**Application Reference 2024/90421**

**Proposal: Erection of single storey ancillary store/office accommodation/tool shed/toilet/kitchen facilities/tasting room at Helme Edge Farm, 31, Crosland Edge, Meltham, Holmfirth, HD9 5RS**

**Consultation Response from KC,  
Highways Development Management**

**2024/90421 Helme Edge Farm, 31, Crosland Edge, Meltham, Holmfirth, HD9 5RS**

Drawing Number 23_811_104

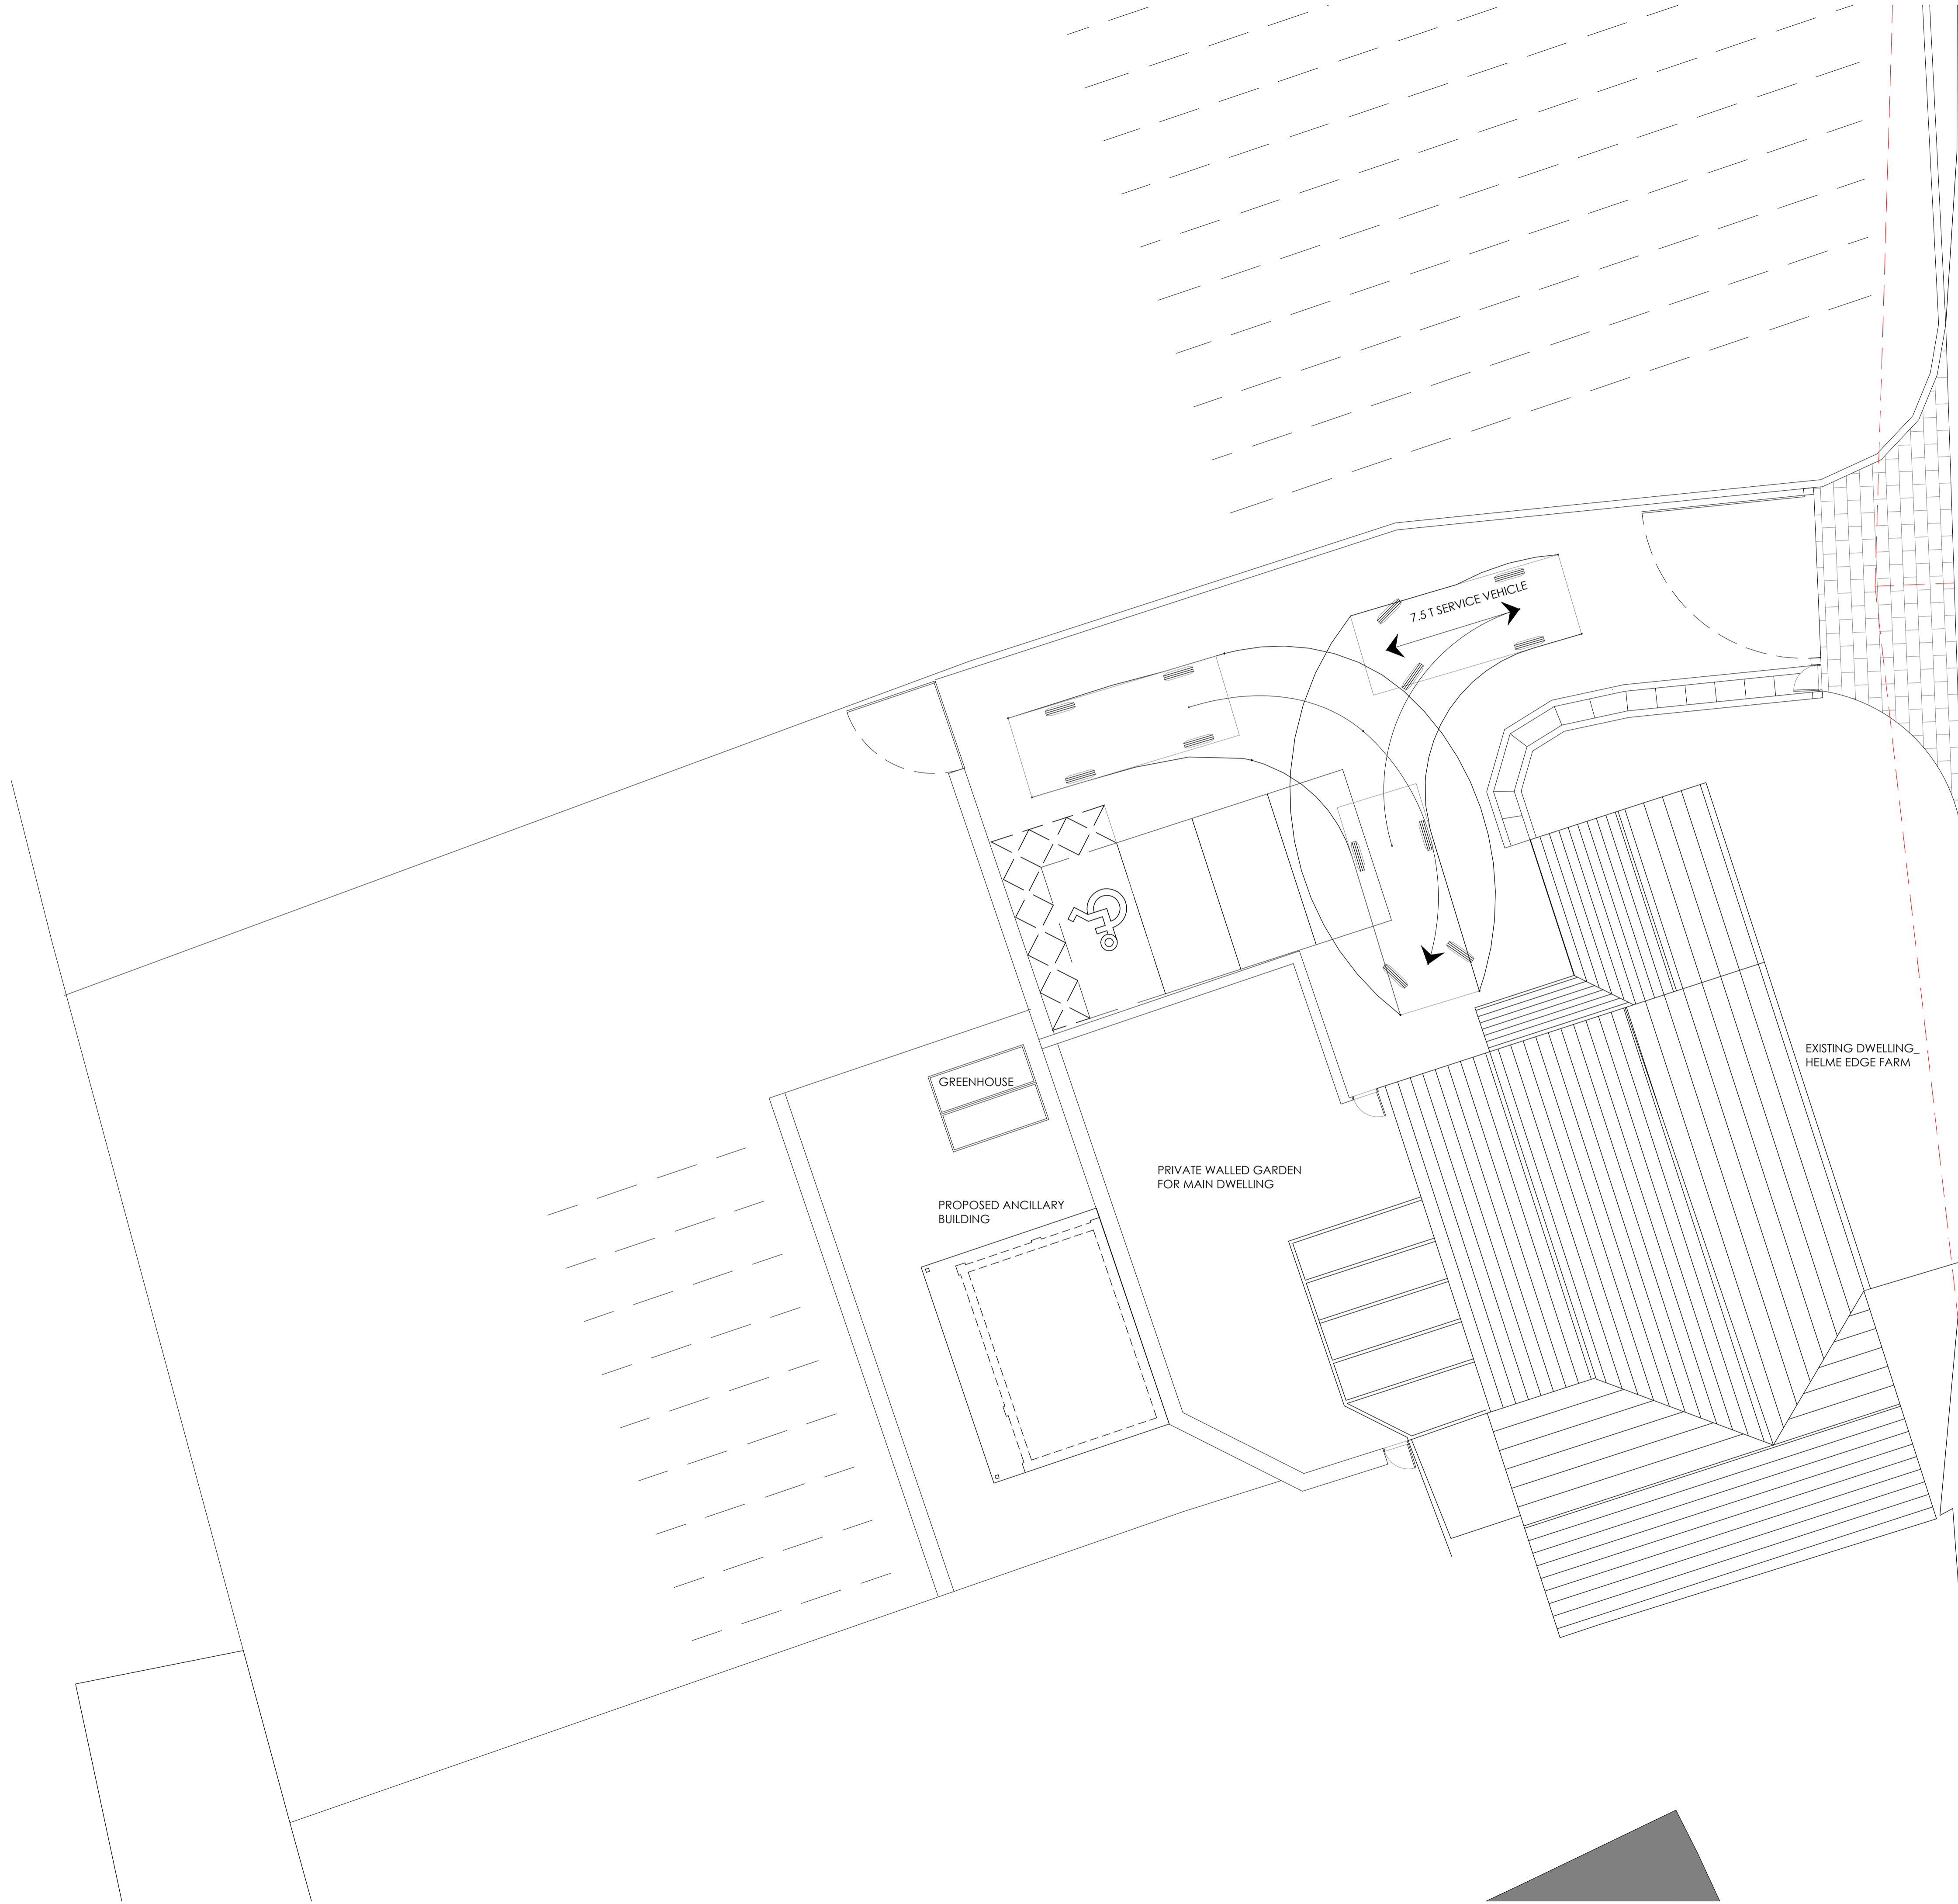
Drawing No 102 (and 104 Rev A) both show part visibility splays of 2.4m x 70m, the visibility splay of 70m to the right would be acceptable, however the visibility splay to the left is almost wholly within the national speed limit zone and so a visibility splay y-distance of 215m would be required. It is noted that on both drawings the full extent of the visibility splay is not shown on the drawing. The drawings both indicate that the boundary wall for the site will be lowered to no higher than 600mm and this is acceptable providing the full splay length is achievable.

We would need to see that the required visibility splay is achievable to the left for vehicles leaving the site to enable us to fully assess the access for highway safety and this will need demonstrating on a drawing along with the full extent of the visibility splay to the right.

Based on the calculations above, there is a visibility splay requirement from the access, to southbound vehicles, of 2.4m x 63m. The drawing attached at **Appendix C** demonstrates this visibility splay (Drg. No. P2709 – D - 1001). Based on the calculations above, the visibility requirement to the south of the access is 2.4m x 42m. To the south of the access, in reality, visibility in excess of the DMRB requirement can be achieved, to the point where vehicles approach around the bend to the south. With this in mind, no amends are required to the south of the access.

Regarding the visibility splay requirement to southbound vehicles, the visibility can be achieved within the applicant's control, with the existing boundary wall to be reduced in height to less than 0.6m
